## General Public Submissions

Issue	Number of Times Raised	Response
Removal of Endangered Ecological Community	41	The development footprint has been modified to reduce impacts to both threatened ecological communities and adjacent native vegetation. Details of the revised Masterplan are provided in the covering Response to Submissions report and revised Biodiversity Assessment Report ( <b>Appendix J</b> ).
Excessive height	7	<p>The exhibited Masterplan building envelopes were within the permissible maximum height for development on the site, as prescribed by the Ryde Local Environmental Plan 2014 (RLEP). Whilst the revised Masterplan includes building envelopes which seek to vary this maximum height in order to respond to the submissions relating to the provision of open space, the building envelopes have been deliberately designed and located to minimise impacts on the adjoining area. In particular:</p> <p>Overshadowing impacts are limited to Epping Road, the front yard of residential properties on the opposite side of Epping Road and some portions of the Shrimptons Creek riparian corridor. The revisions to the scheme, which include increased setbacks to Epping Road further reduc

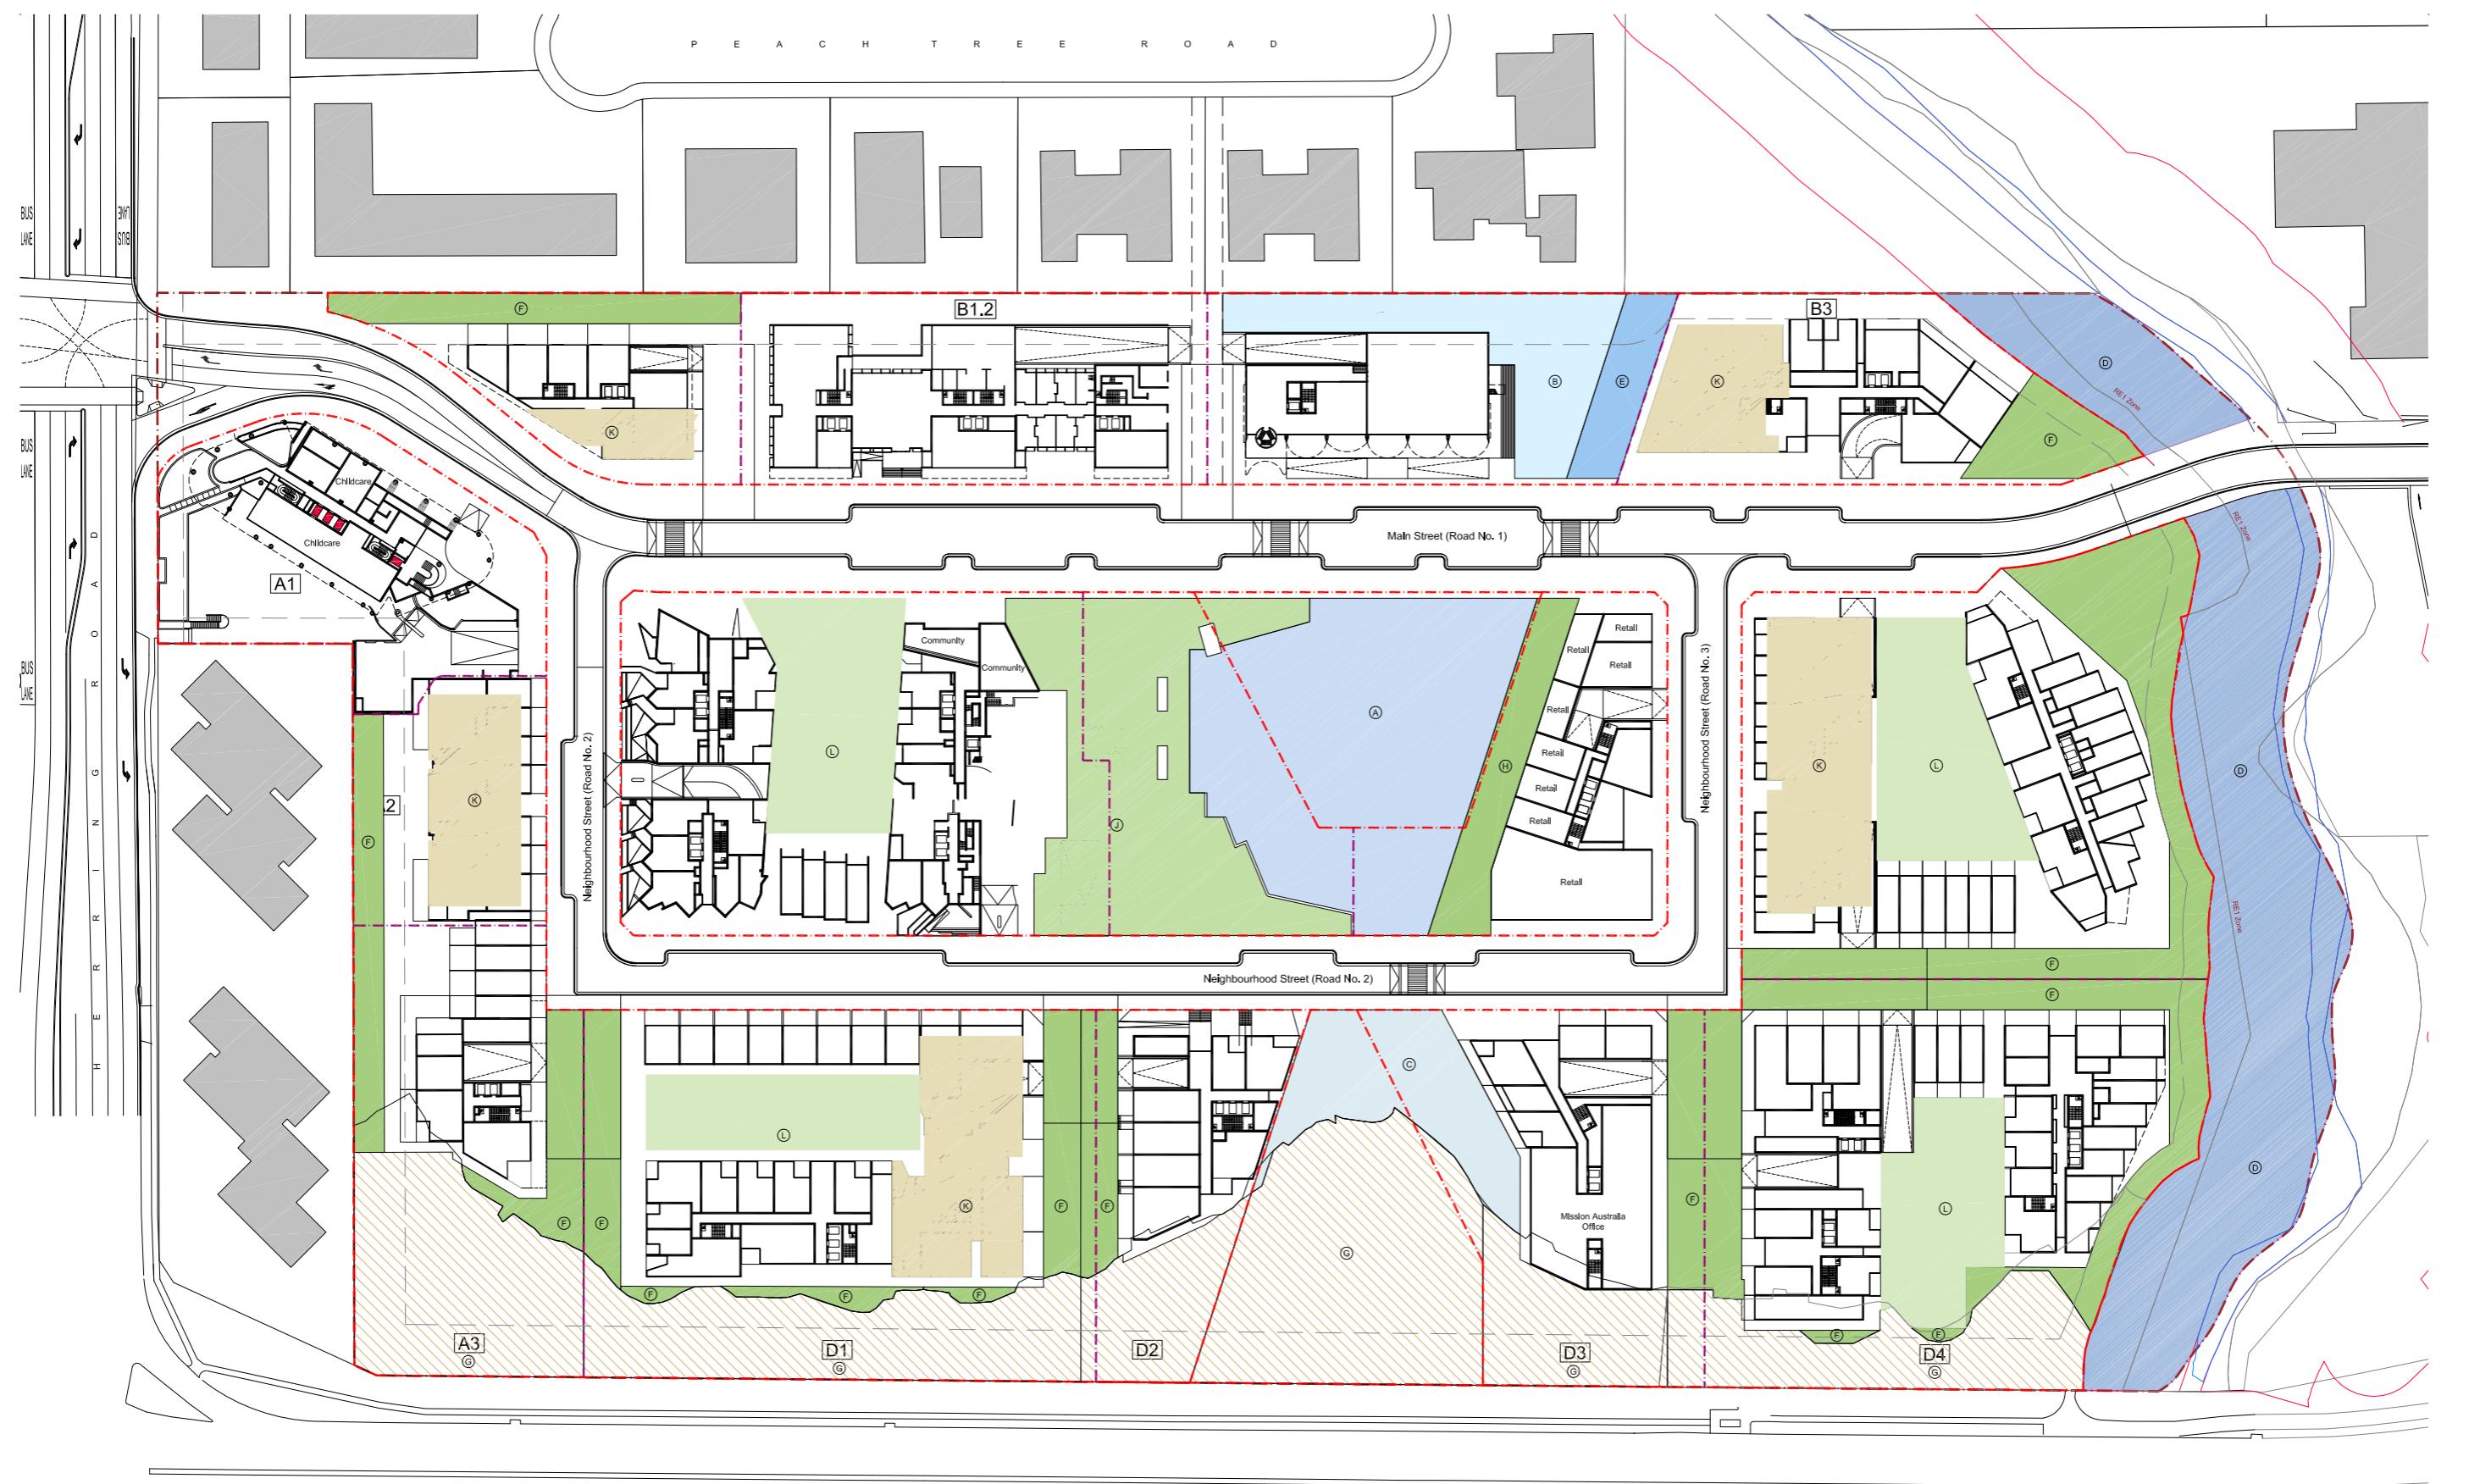
Insufficient open space in the area	3	<p>The Masterplan, as amended, includes additional open space, from that of the original Masterplan. Please refer to attached drawing DA02.MP.202(B) which details the active and passive open spaces of the indicative reference scheme and details the overall area of open space across the site.</p> <p>This is described in further detail in the covering Response to Submissions report.</p>
